**ADC Planning Consultation
Conservation/Design Officer Response**

Application Number	LU/256/17/L
Address	12 River Road Littlehampton BN17 5BN
Description	Application for listed building consent to remove 1st floor partition to create large sitting room.
Case Officer	Mr D Easton
Date	19 th December 2017

1st FLOOR PLAN 1:50@ A3

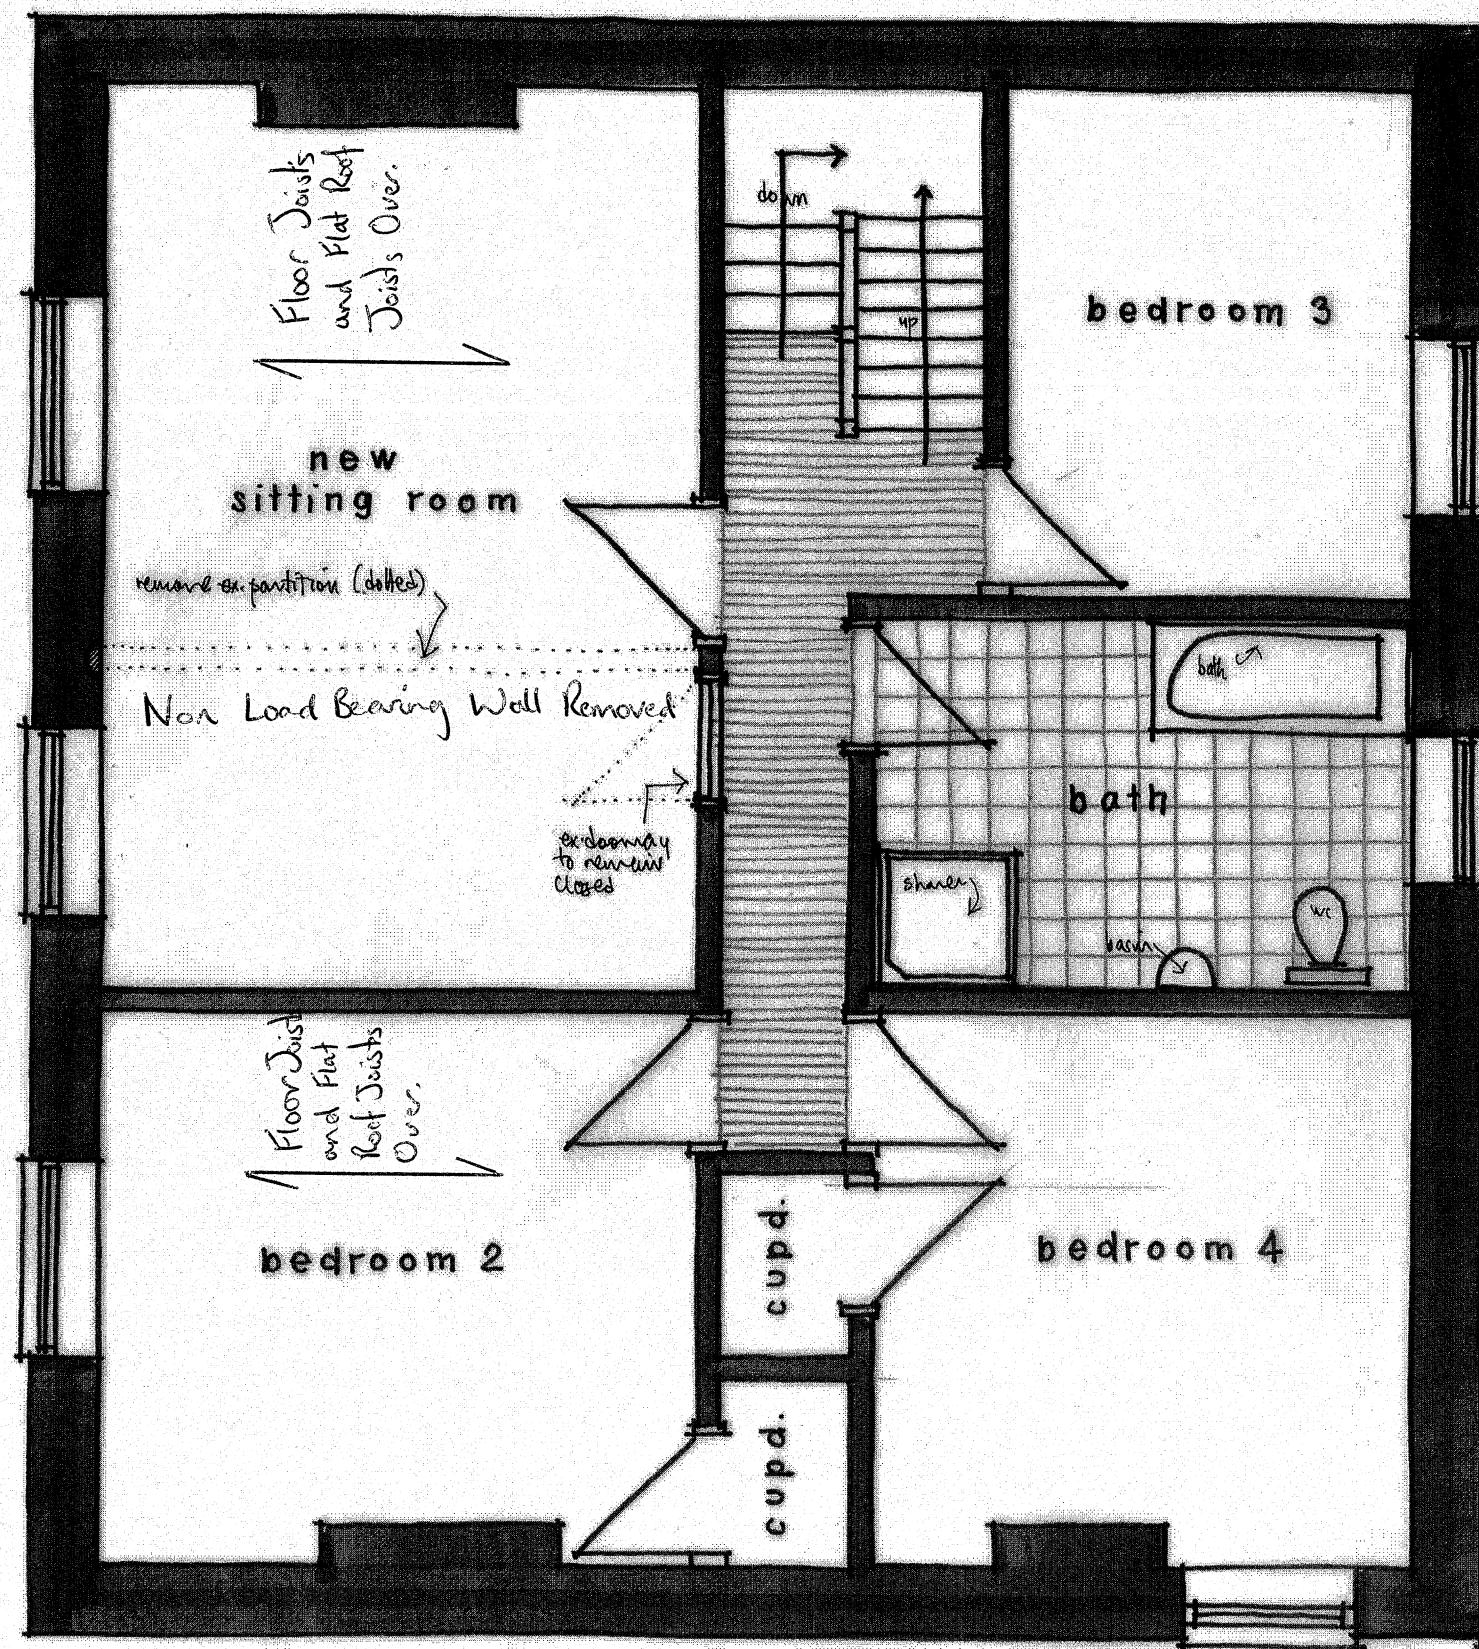
The proposal is to remove a partition to first floor in a listed building. The application / heritage statement do not make an Assessment/Statement of Significance of the proposed works. However the Structural Engineers report states the wall is non-loadbearing, so no intrusion would be made to ensure structural stability.

From the plan form, it is unlikely that the wall to be removed is original, given the location of windows, the fireplace and general symmetry of the space.

There is therefore no objection to the removal of the wall, subject to all skirtings, cornice, dado, door and architrave be retained where possible and like for like making good of such details.
